Submission by Cllr John Walsh

29 August 2022

Re: Case reference: HA29N.313892 – Blanchardstown to City Centre, Bus Connects Core Bus Corridor

PLAN ON PROPOSED SOUTHERN RAMP AND STAIRS (RW07-A)
SCALE: 1:150

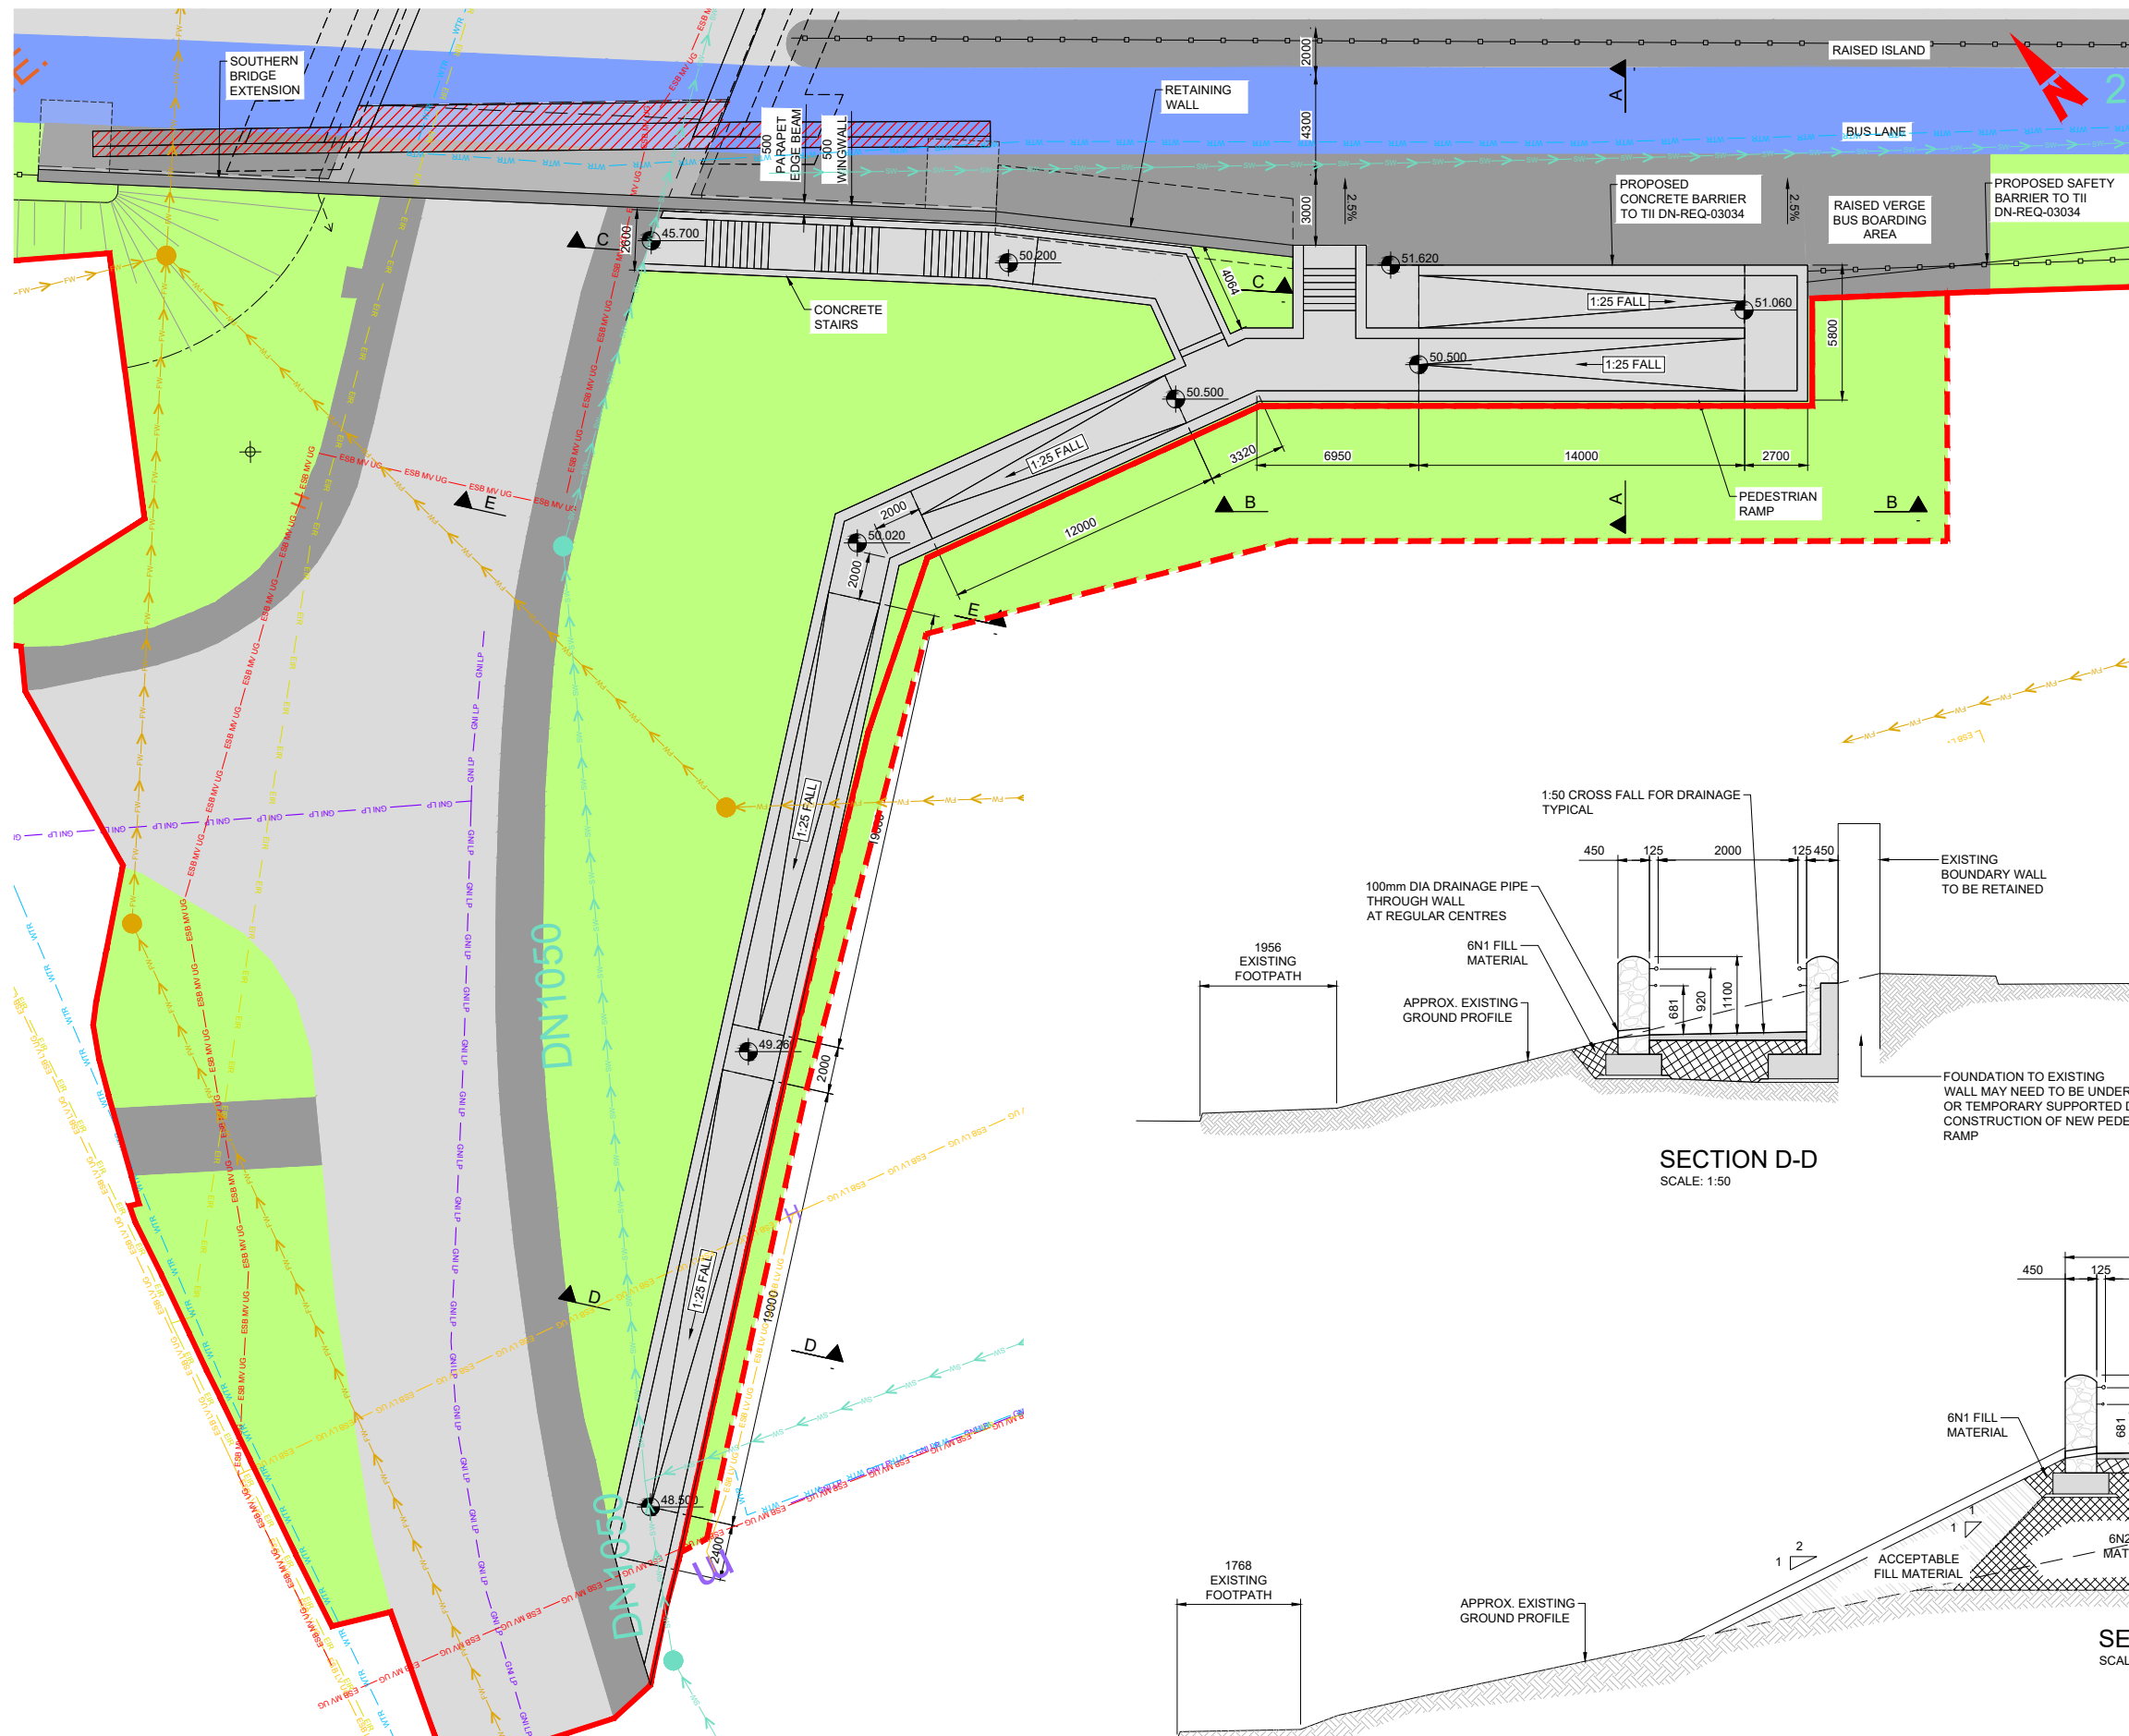
I wish to raise concerns about the environmental impact of the works very close to the bank of the Tolka on the northern side of the N3 under the bridge on Mill Road. A large-scale concrete ramp and public lighting could seriously damage the ecosystem along that part of the river and adversely impact on the animals and birds which inhabit that area. Also the proposed cutting down of trees to build ramps should be minimised as much as possible. If the ramps go ahead, existing trees should be protected as much as possible and full mature trees must replace those currently in situ where trees are removed.
